25 November 2020

Stanford House, 9 Nestles Avenue, Hayes UB3 – Daylight, Sunlight & Overshadowing

In addition we have been provided with a letter of 9th November 2020 prepared by Lambert Smith Hampton following a review of our detailed report of July 2020. The Lambert Smith Hampton letter raised some queries in respect of our report. We have provided further clarification in respect of these elements below and additional technical information is attached where useful to aid in addressing these queries.

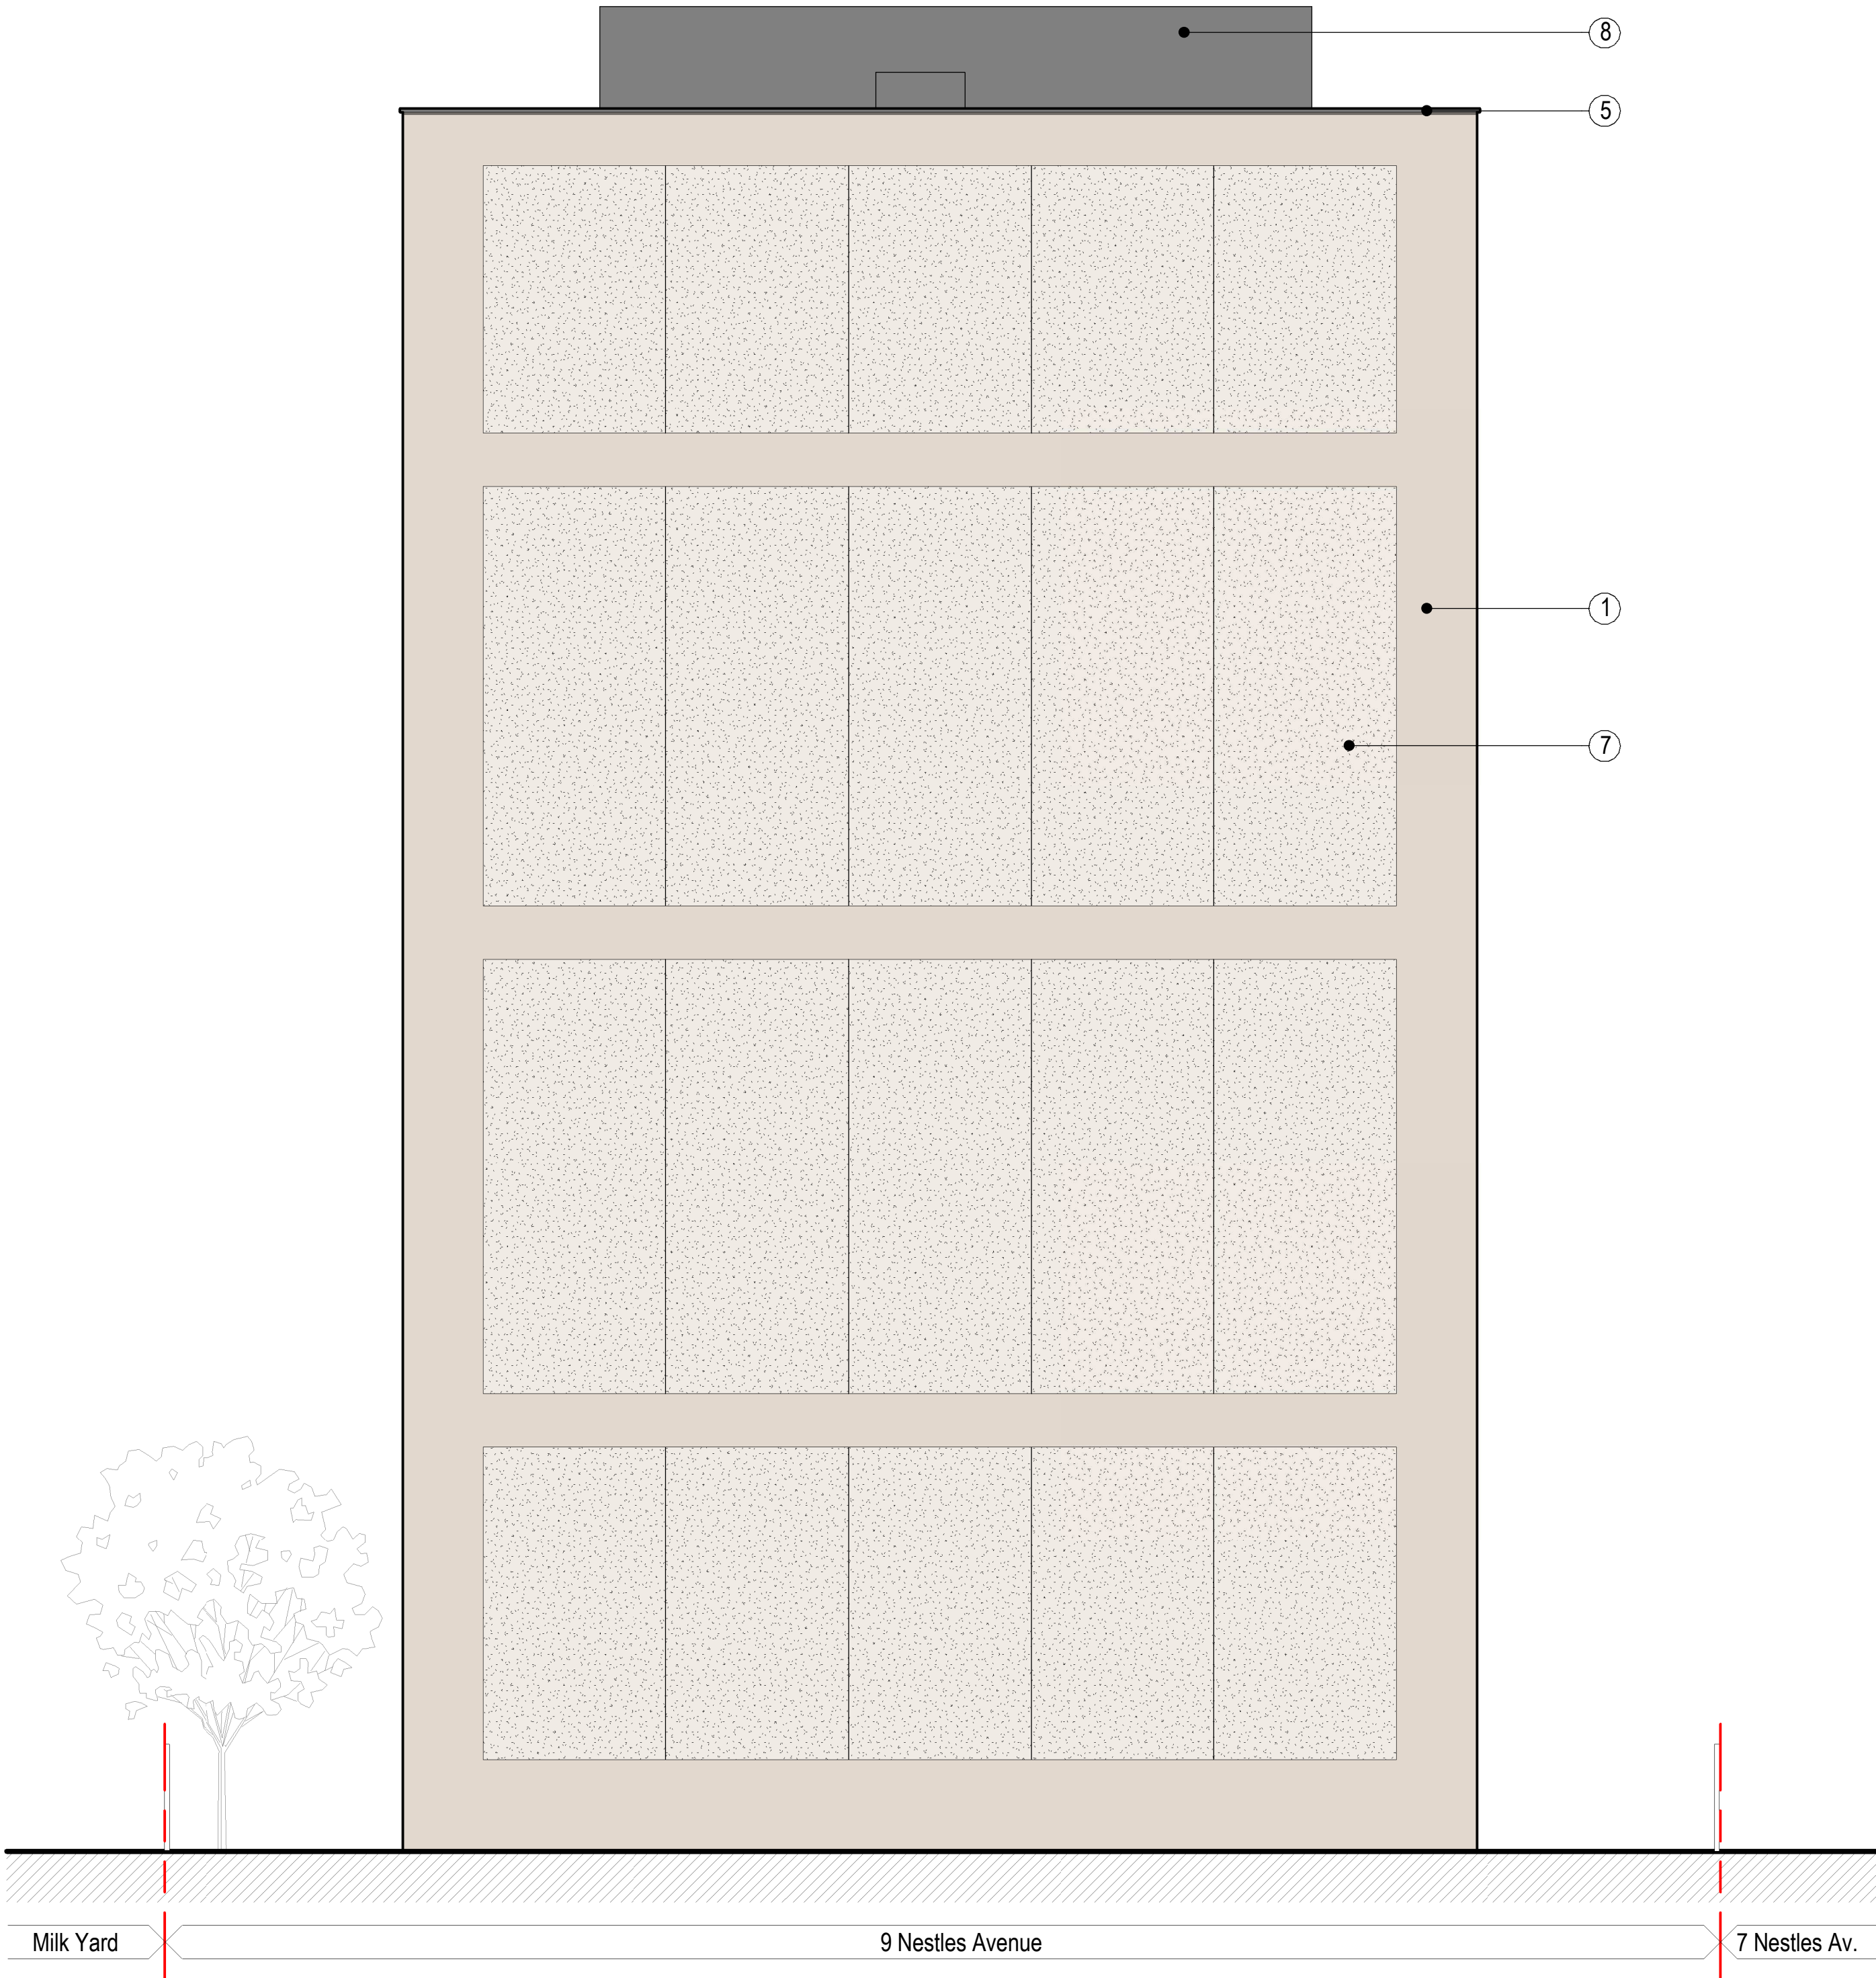
These changes include the redesign and removal of some windows to the southwestern flank elevation where it is closest to the neighbouring site at 7 Nestles Avenue. Glazed elements have been removed additional return windows and a staggered 'bay' element added to retain good daylight levels to these units. The areas of these changes are highlighted below:

Revised western elevation indicating area of proposed changes.

The results of our internal daylight assessment show that the rooms affected by the revisions to their glazing continue to meet the ADF targets for their specific room use. These rooms are identified as First Floor R31 & R32, Second Floor R29 & R30 and Third Floor R29 & R30.
